Application No. H08/1152/01/A1

PROPOSED EXTENSION ONTO EXISTING DWELLING TO FORM ANNEX.

Amendment: Addition of first floor window and revised gable end
Dwg.No. MW002/1/2001B

TOWN AND COUNTRY PLANNING ACT 1990
NOTICE OF ACCEPTANCE OF AMENDMENT

DRG No. MW.002/1/2001

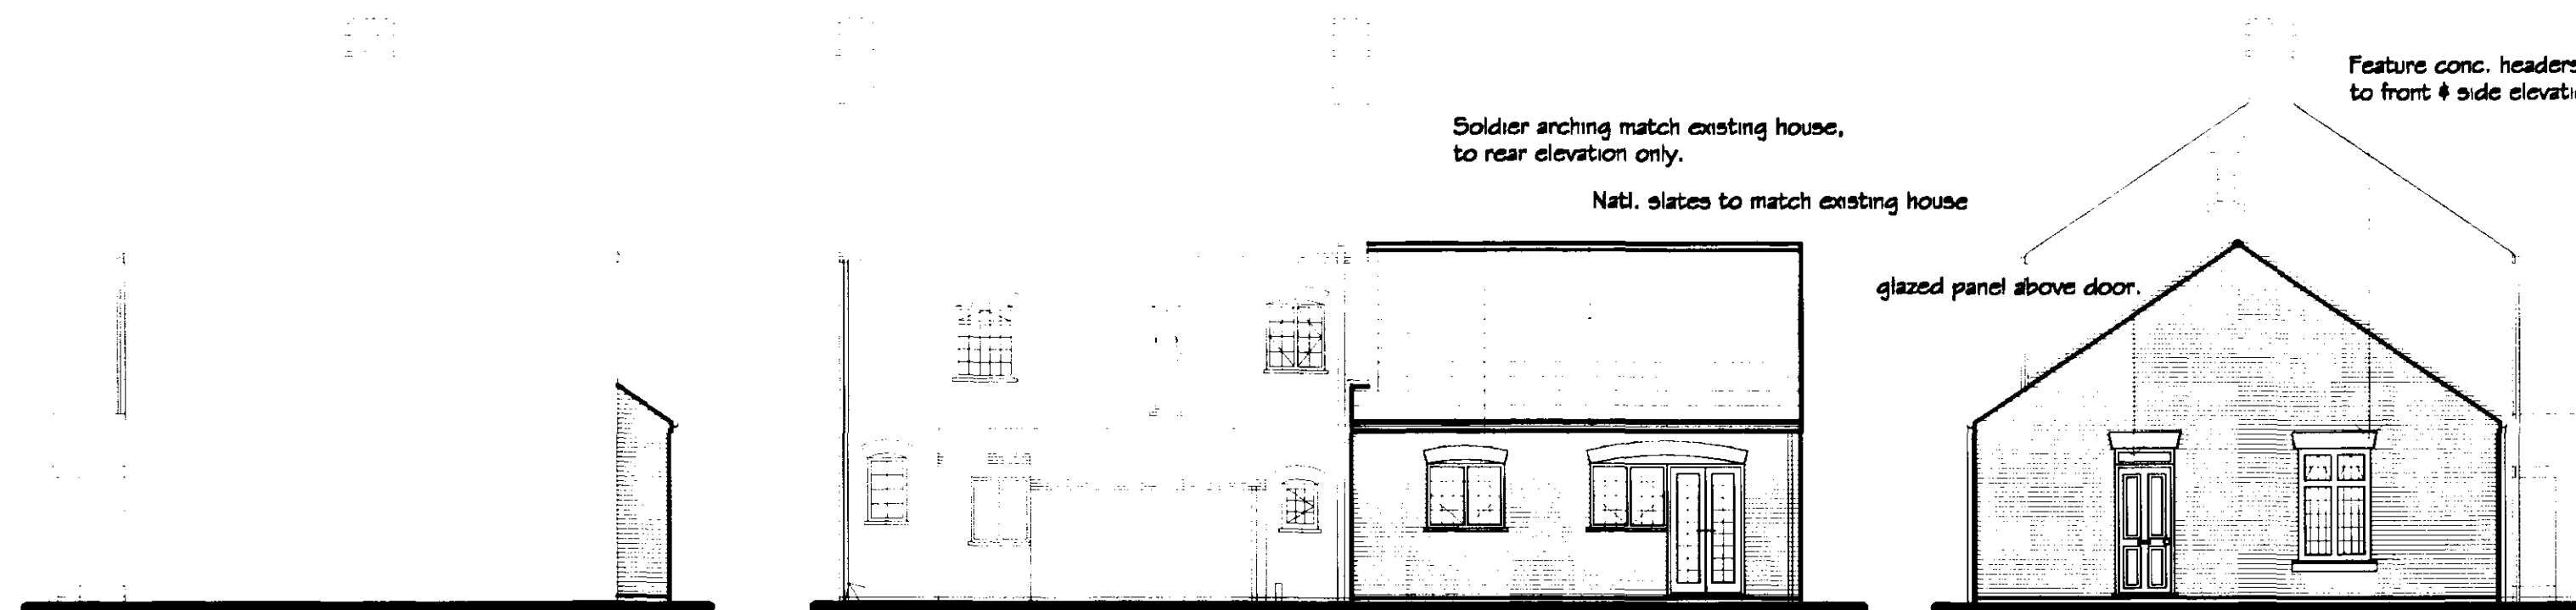
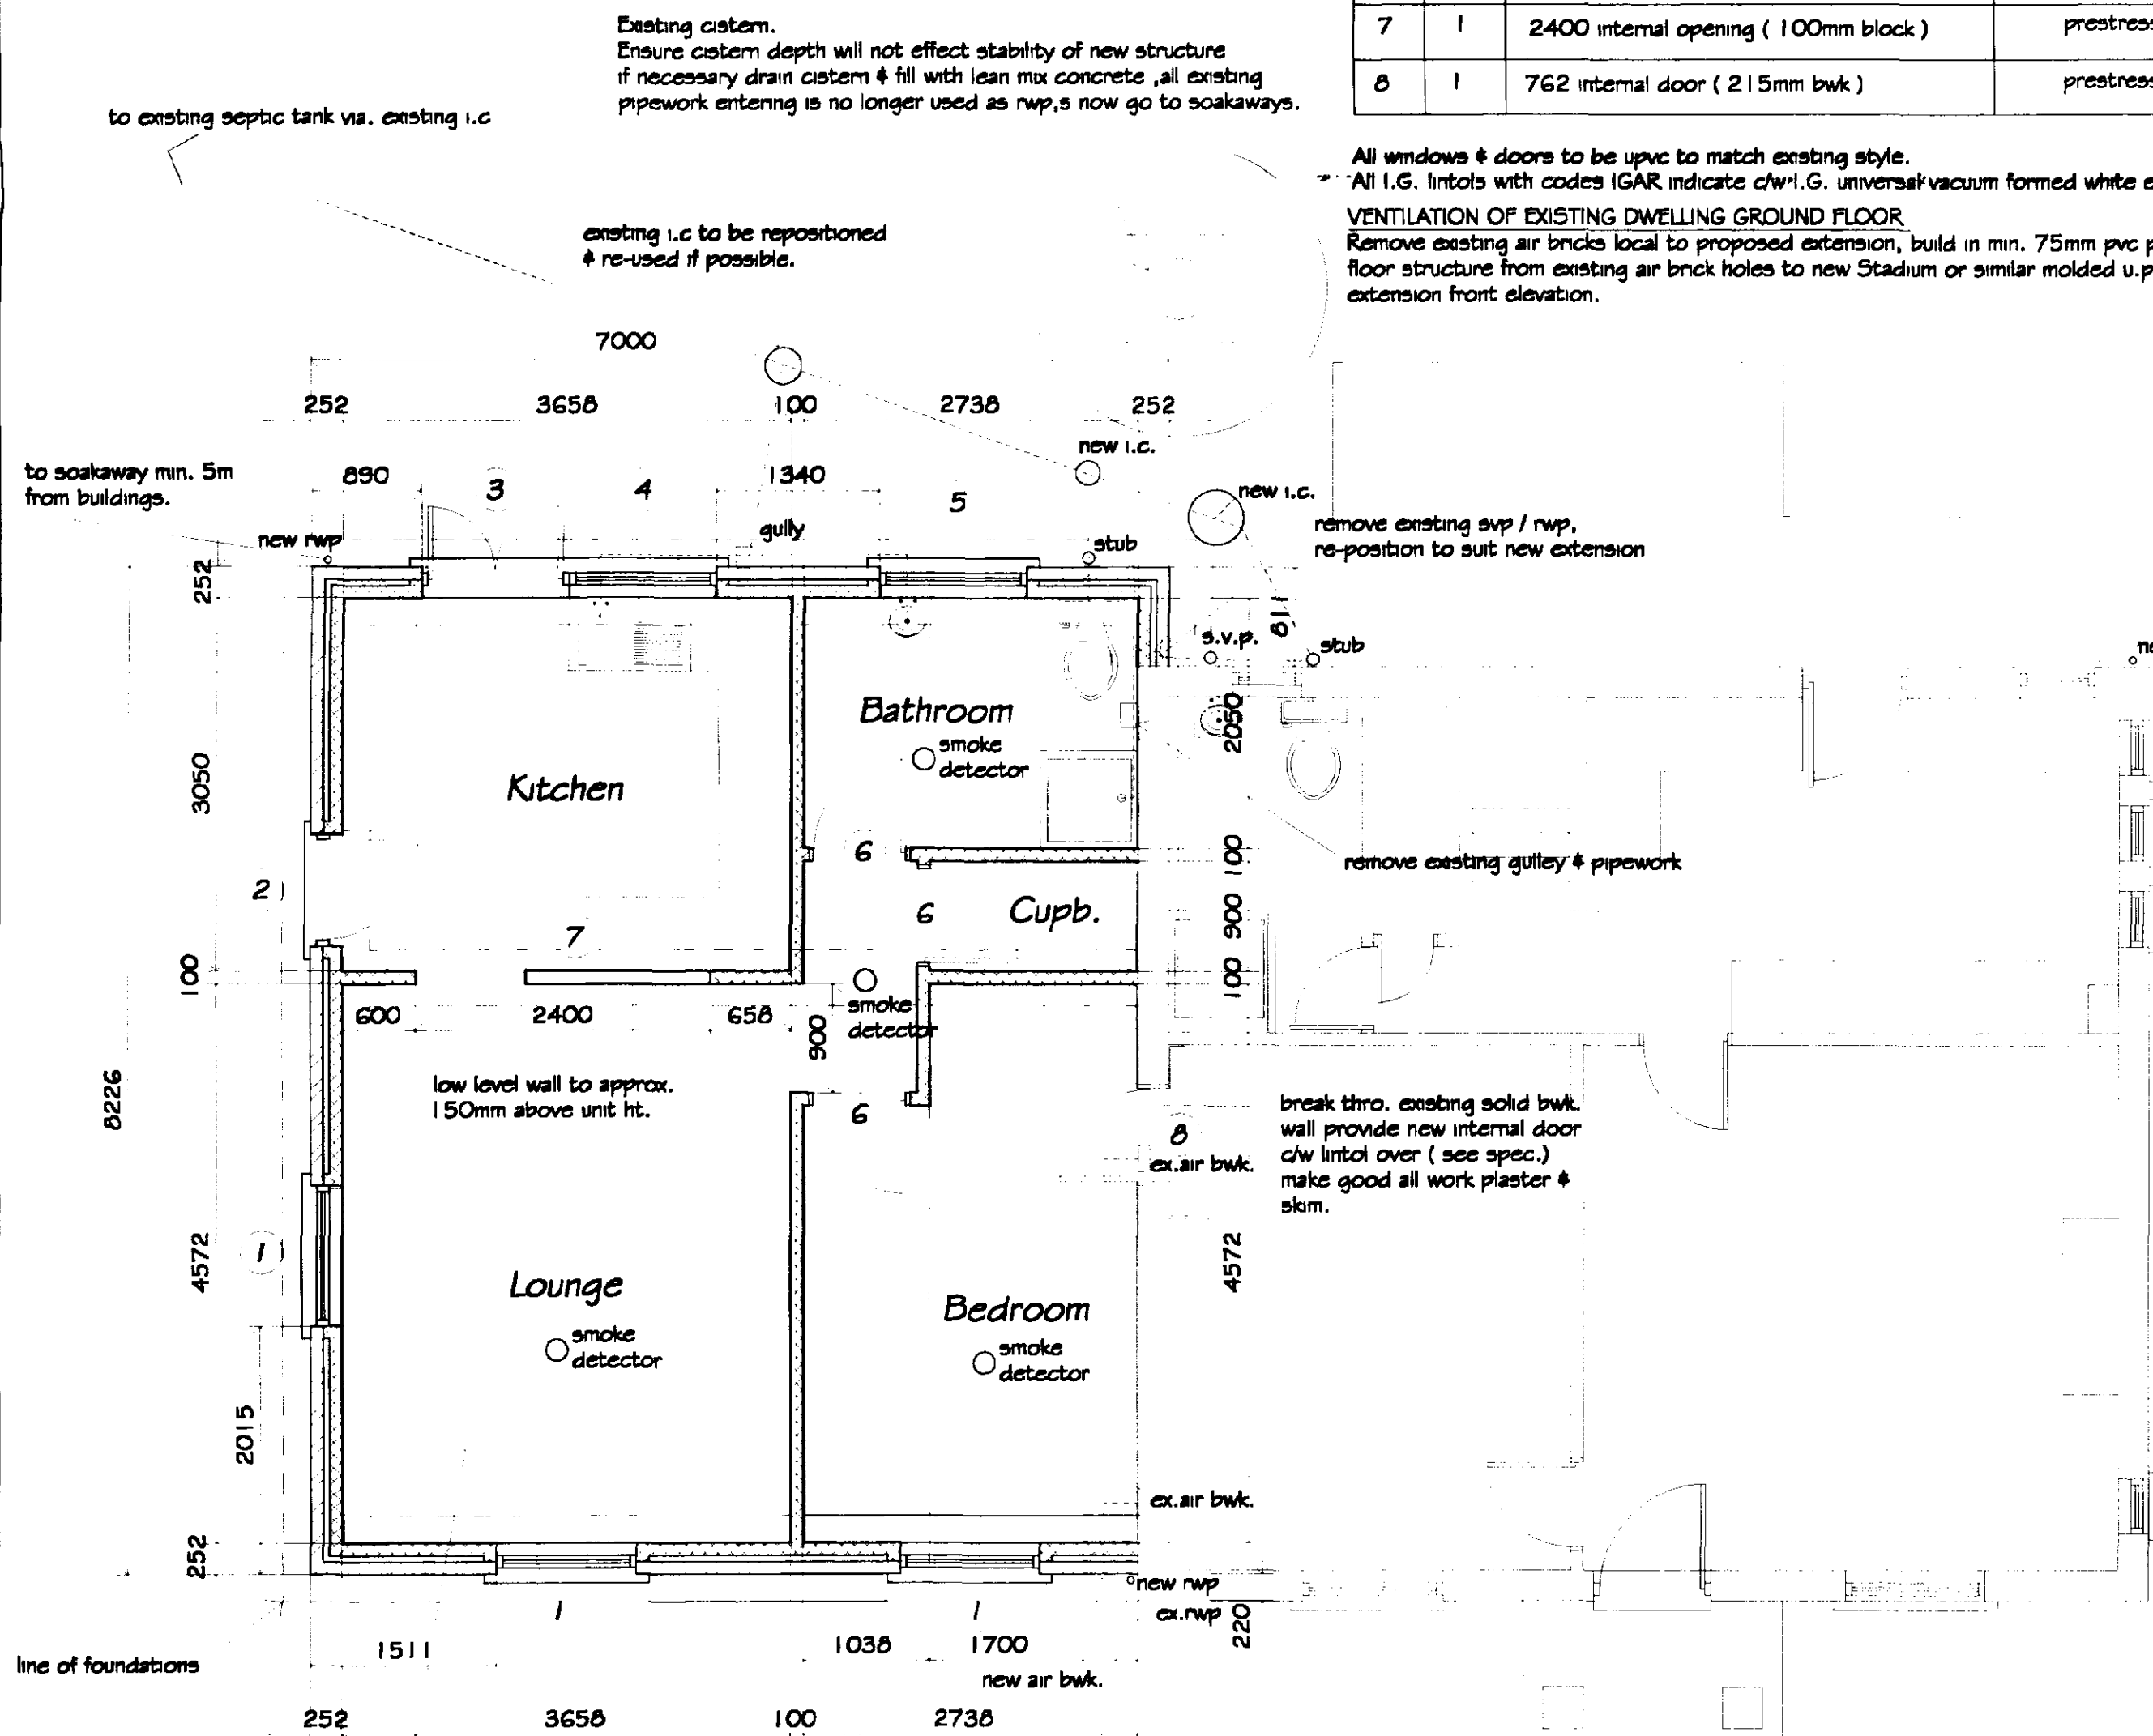
WINDOW ADDED TO FIRST FLOOR ON NEW GABLE END EXTENSION

The amended details submitted in respect of the above proposal have now been considered and there are no objections to the amendment being implemented to the extent described above.
